Date: 13-Oct-2015  
Our Ref: 2015/62/92343/E

I refer to your planning application received on 23-Jul-2015 for Part demolition and conversion of mill to form 18 residential units at Warwick Mills, Warwick Road, Batley, WF17 6BS, application number 2015/62/92343/E.

**Drawing:**  
 Ground Floor Drainage Plan  
 As Existing

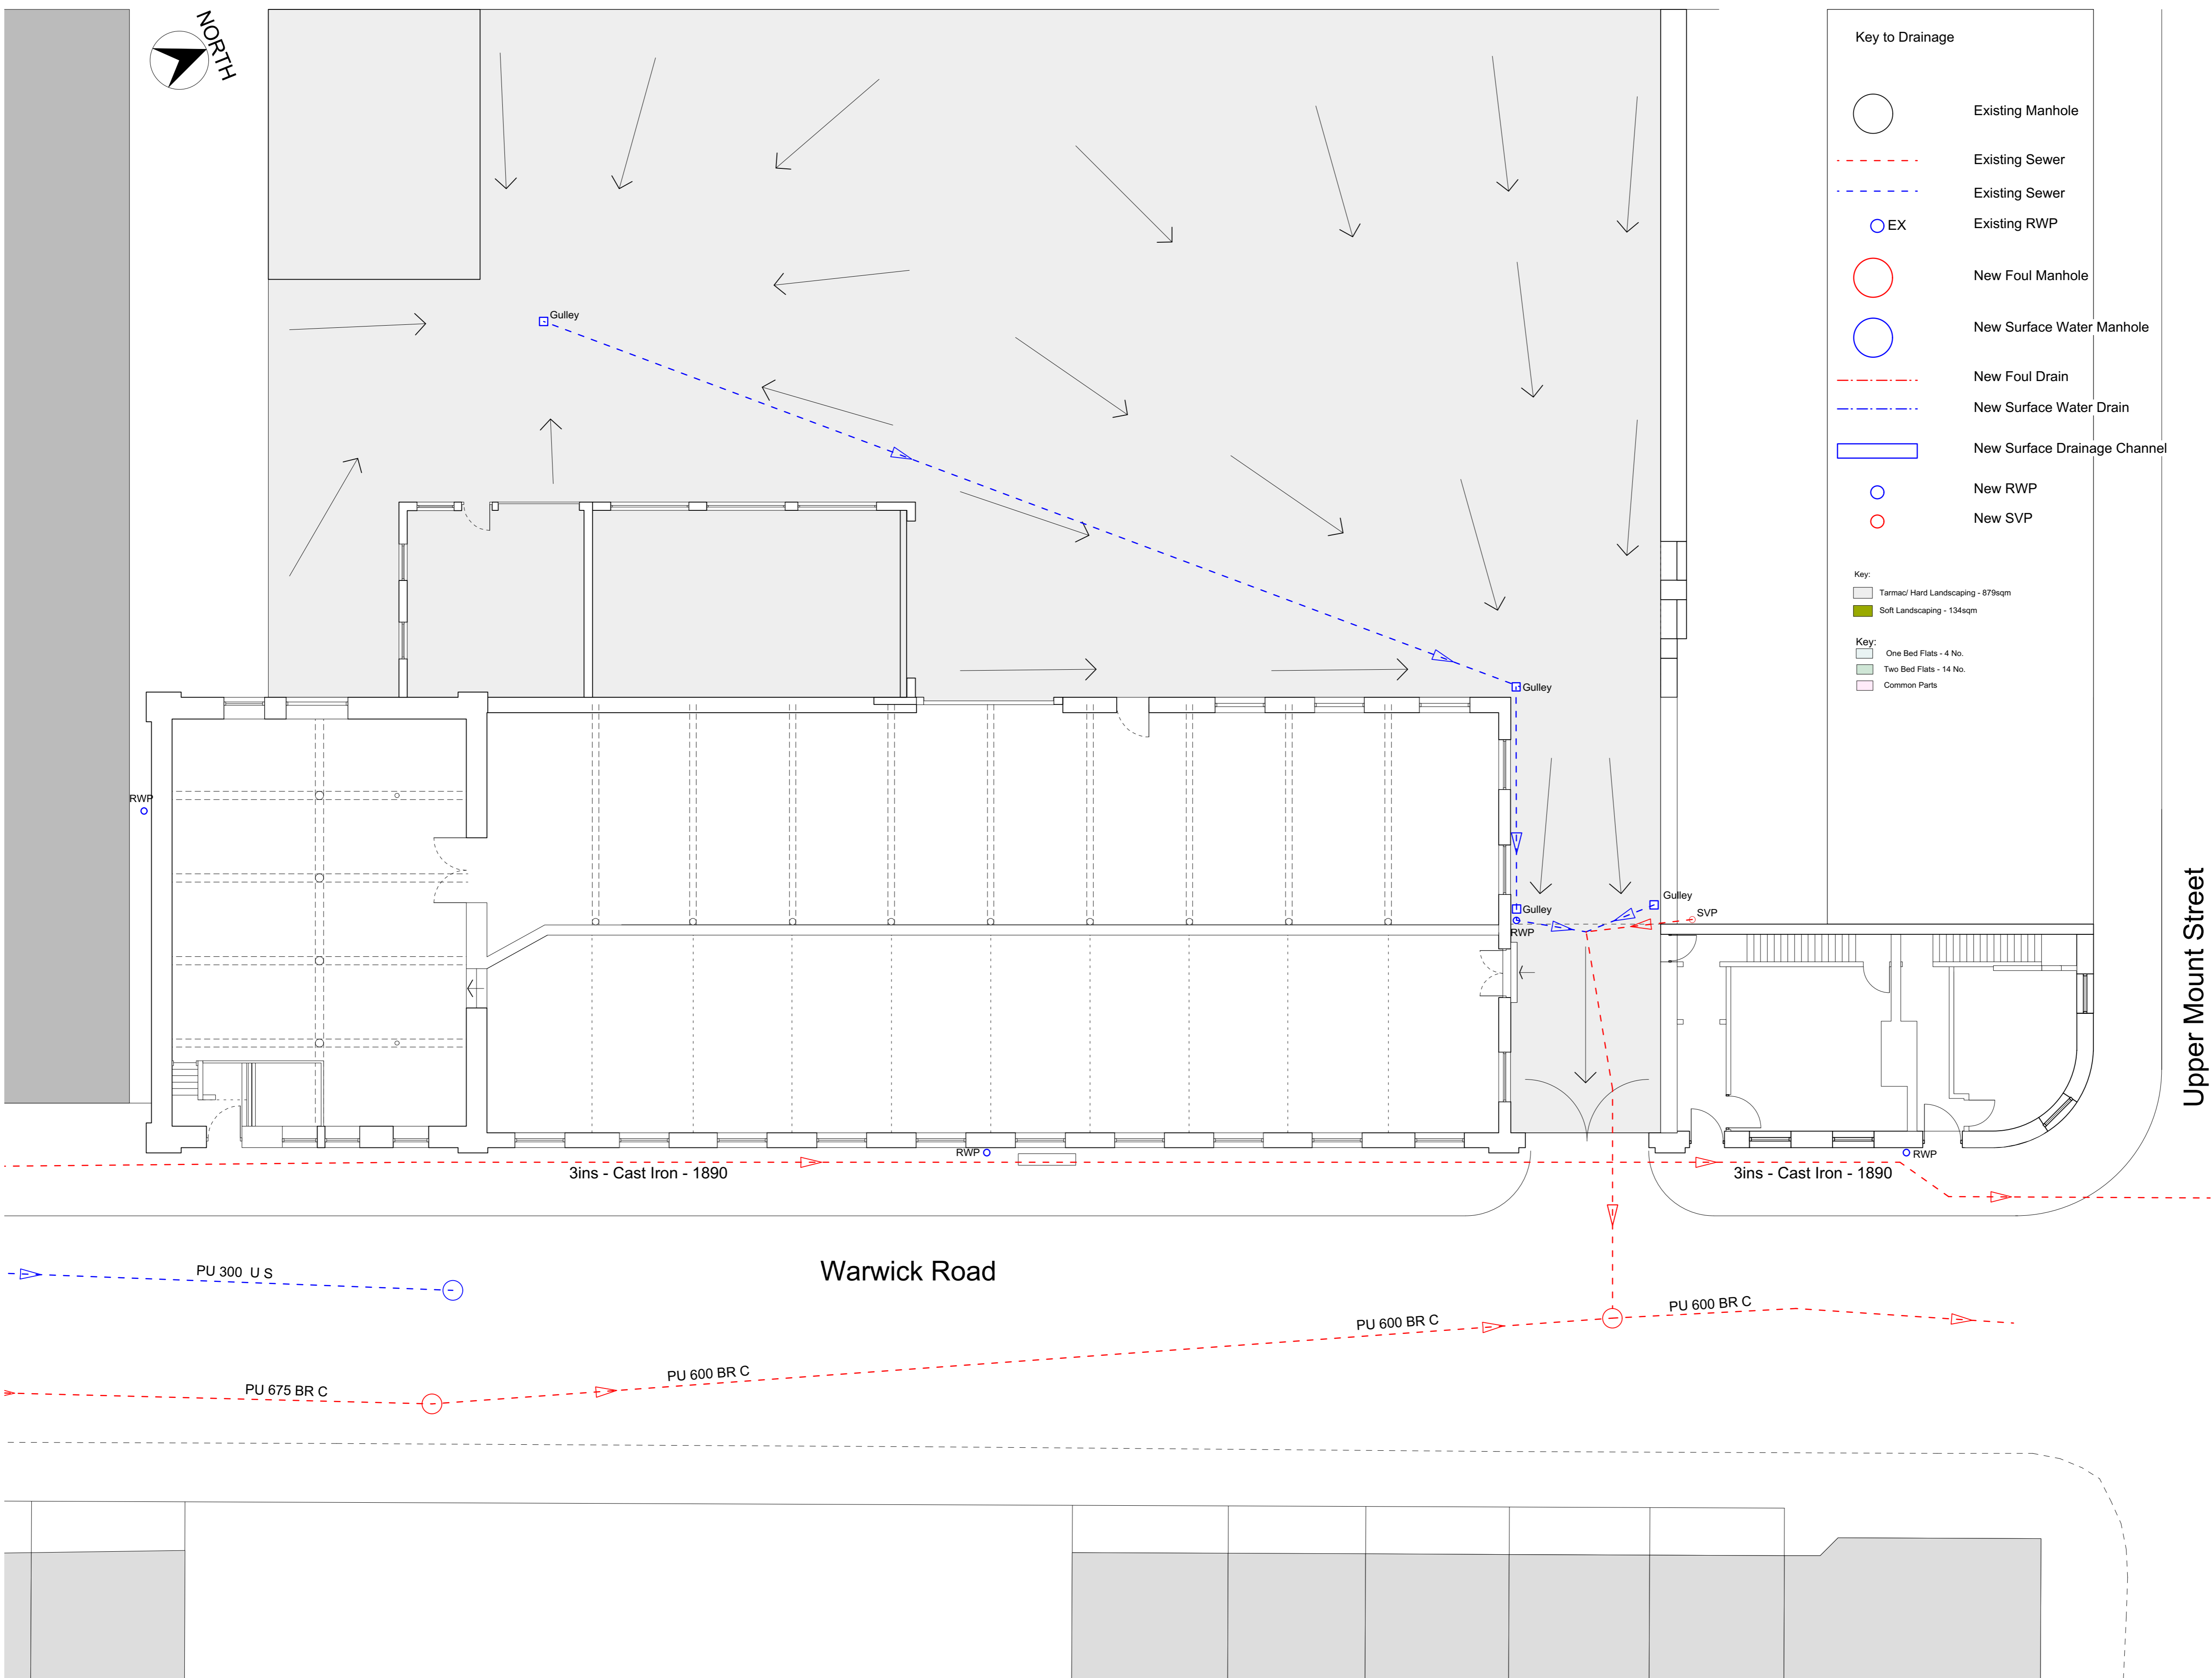
1. Details of how long the property has been marketed for, with whom and whether there have been any expressions of interests as a result of this marketing.
2. Evidence of existing positive drainage to a public sewer from the site boundary. The drainage plan shall include surface water storage and flow control rate.
